**WEST SUSSEX COUNTY COUNCIL
STRATEGIC PLANNING CONSULTATION**

FROM: Ian Hayward
TO: Arun District Council
FAO: Ross Leal
SUBJECT: M/59/15/DEM

80-86 Elmer Road, Middleton-On-Sea, PO22 6EX

This consultation response deals with a Prior Notification application for the demolition of 4 existing derelict commercial units on the roadside adjacent to Elmer Road.

DRAWING No.
2038/02A

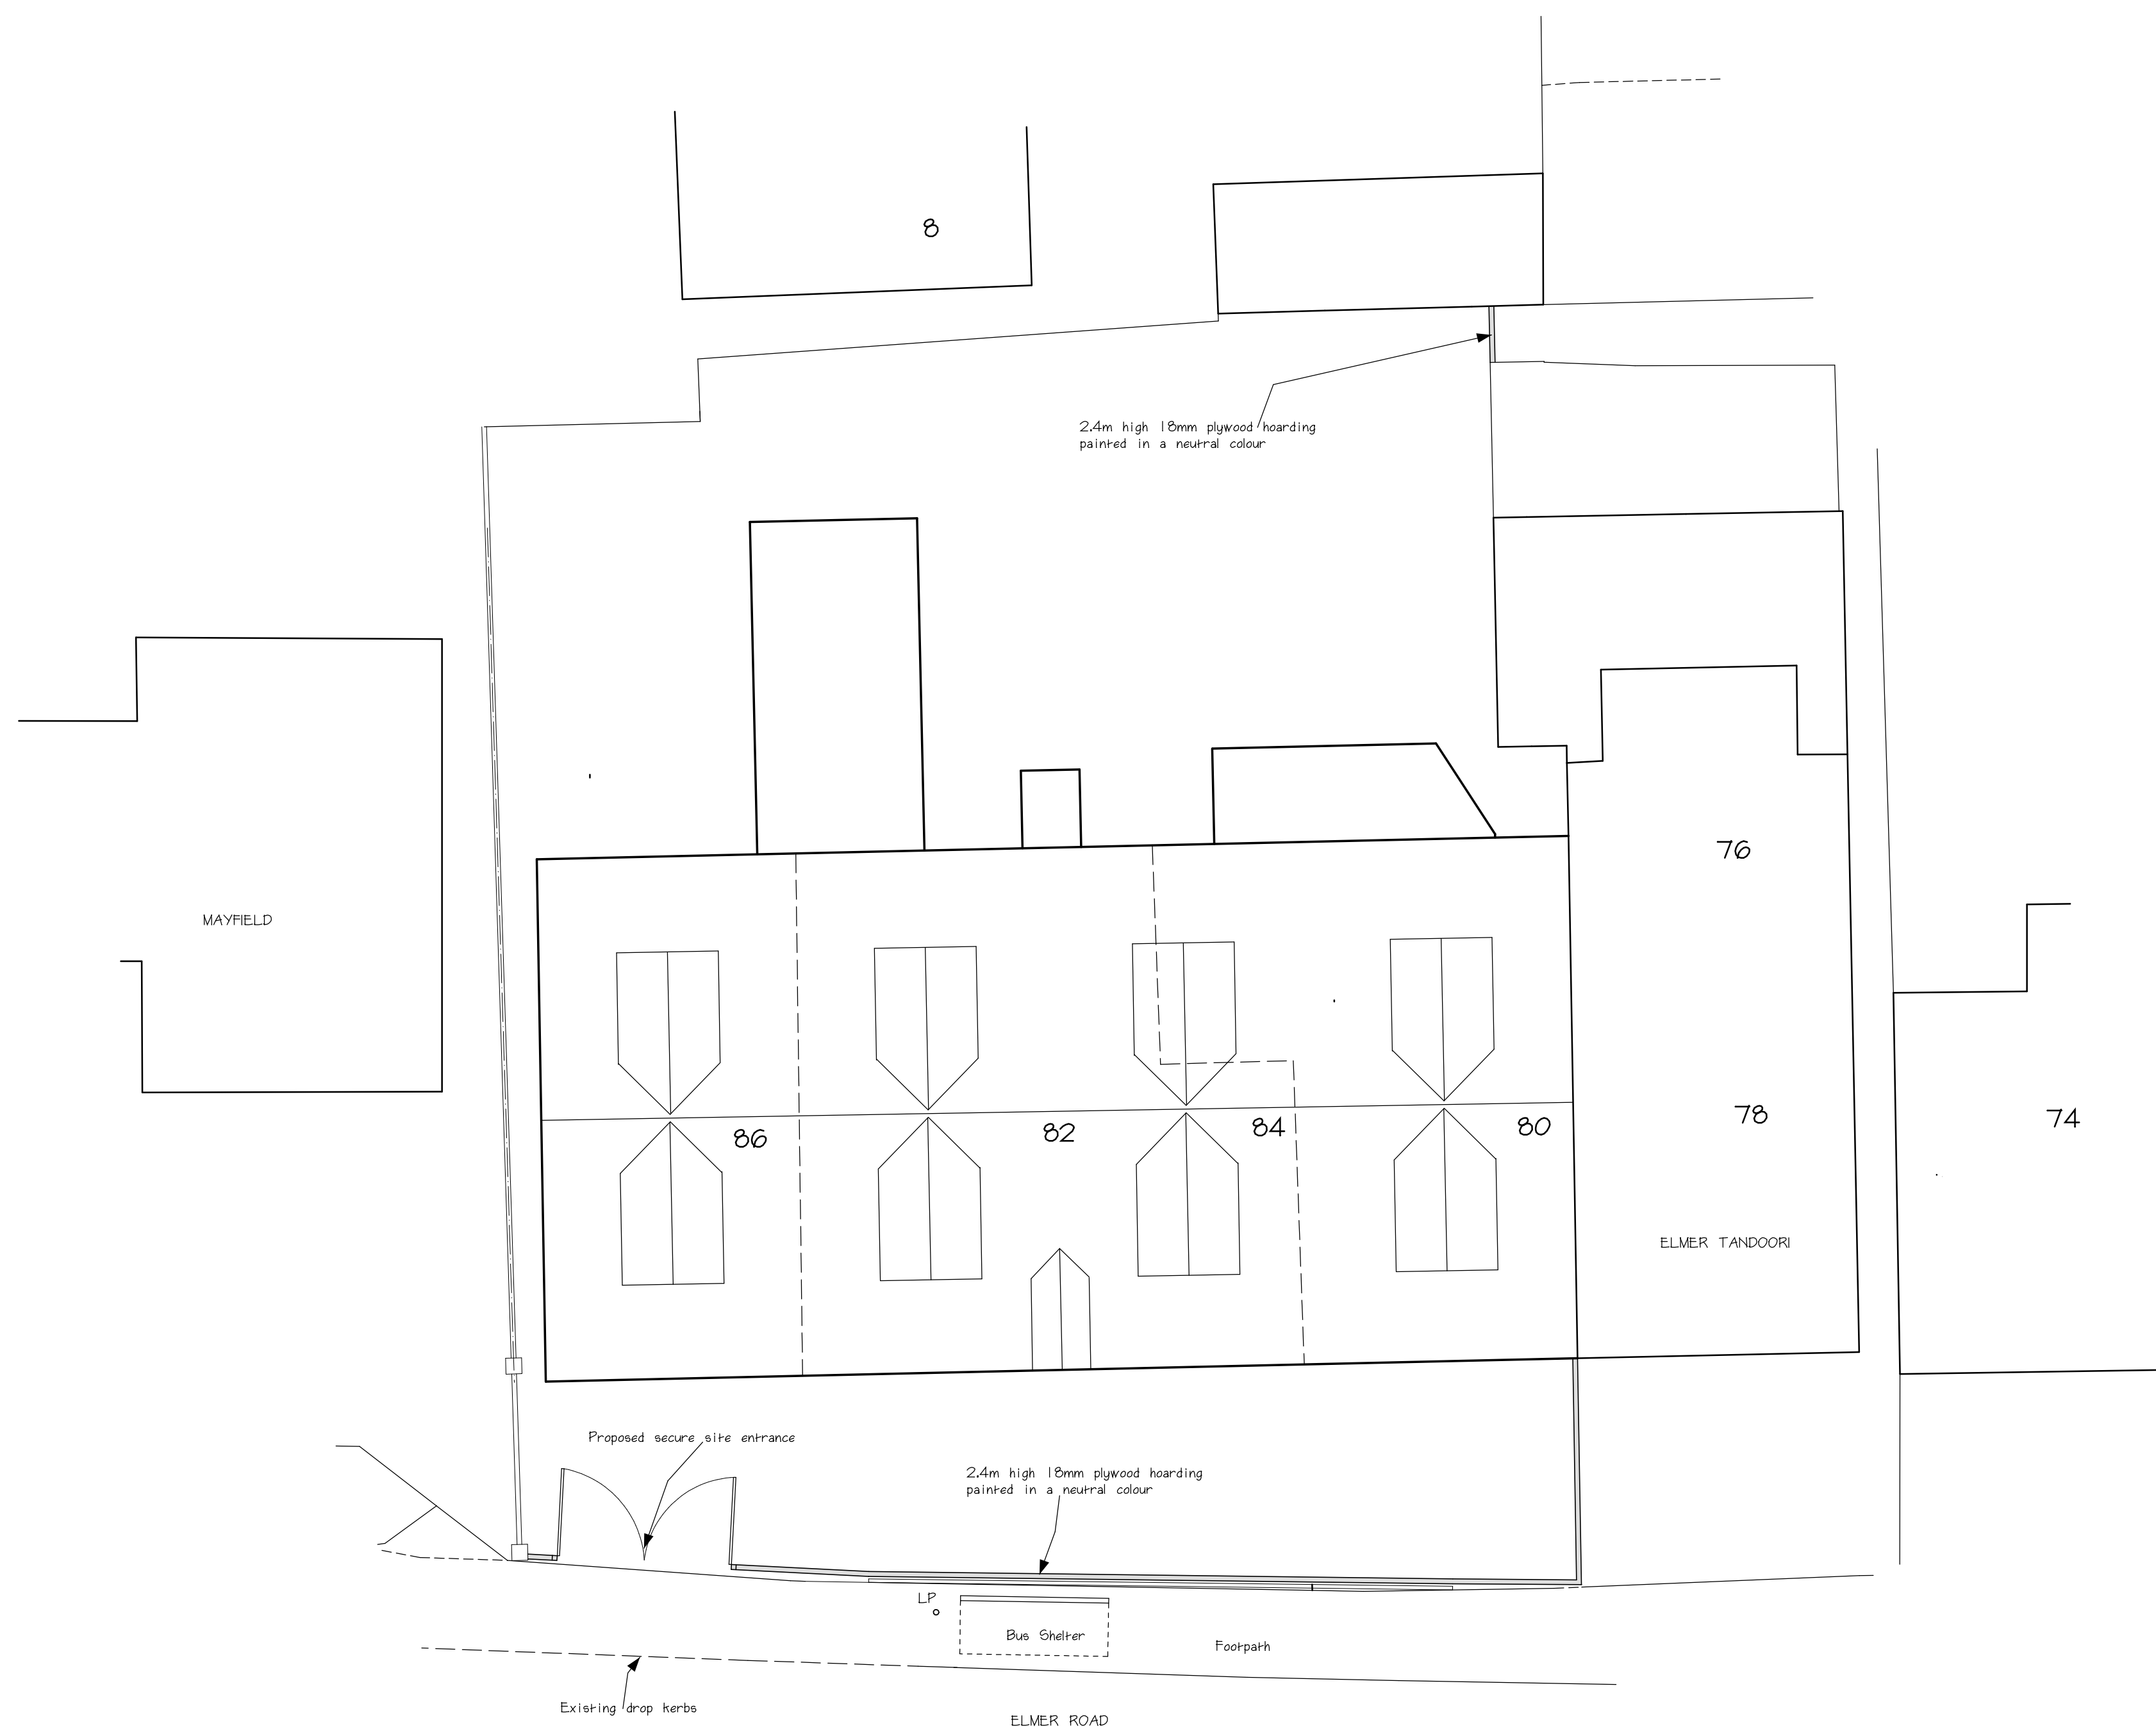
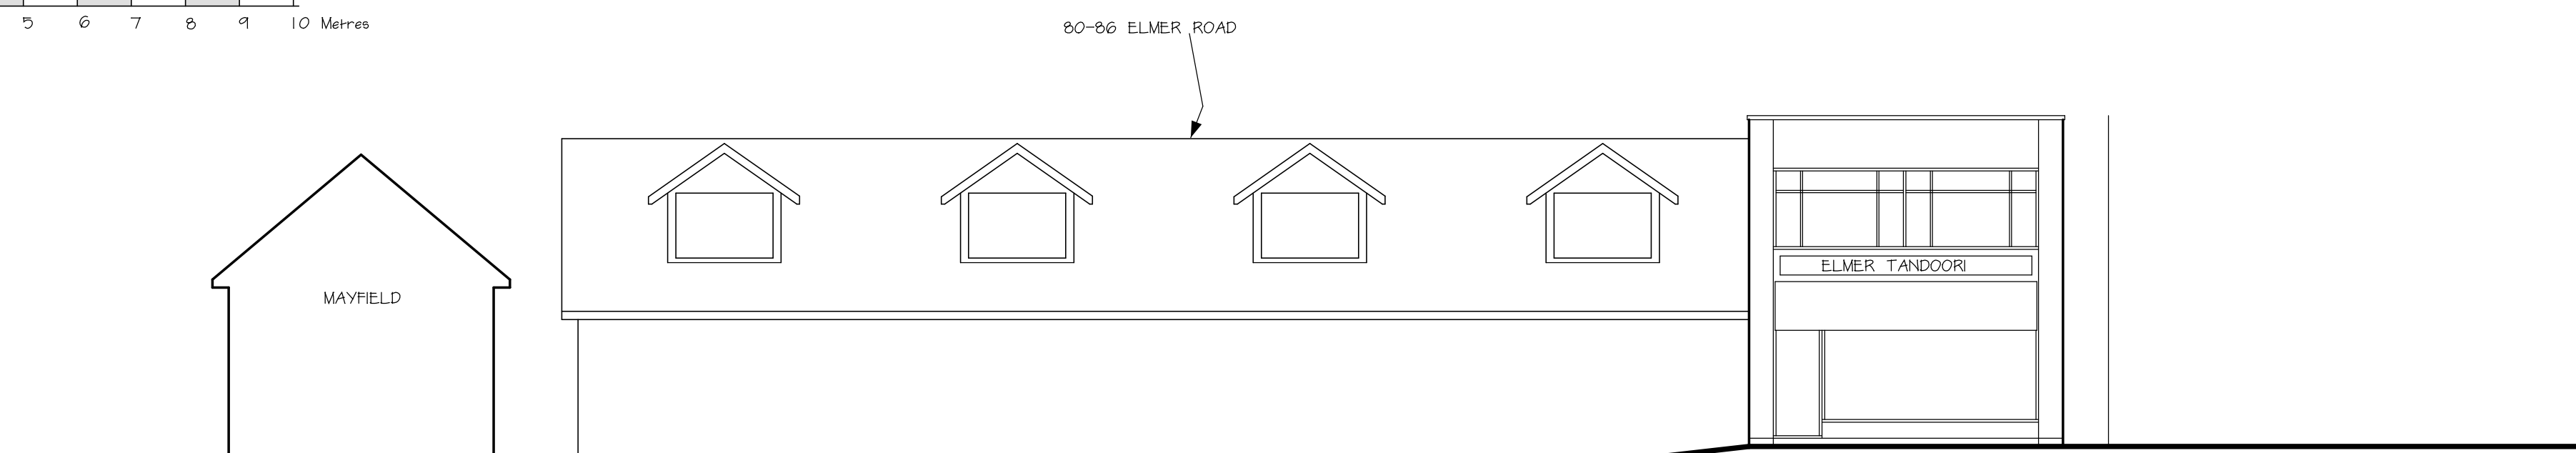
Having observed this area on WSCC mapping, the proposed hoardings marked on plan no. 2038/02A would be placed on private land and not within the WSCC Highway Boundary. The existing dropped kerb access proposed for this is sufficient for use during the demolition phase.
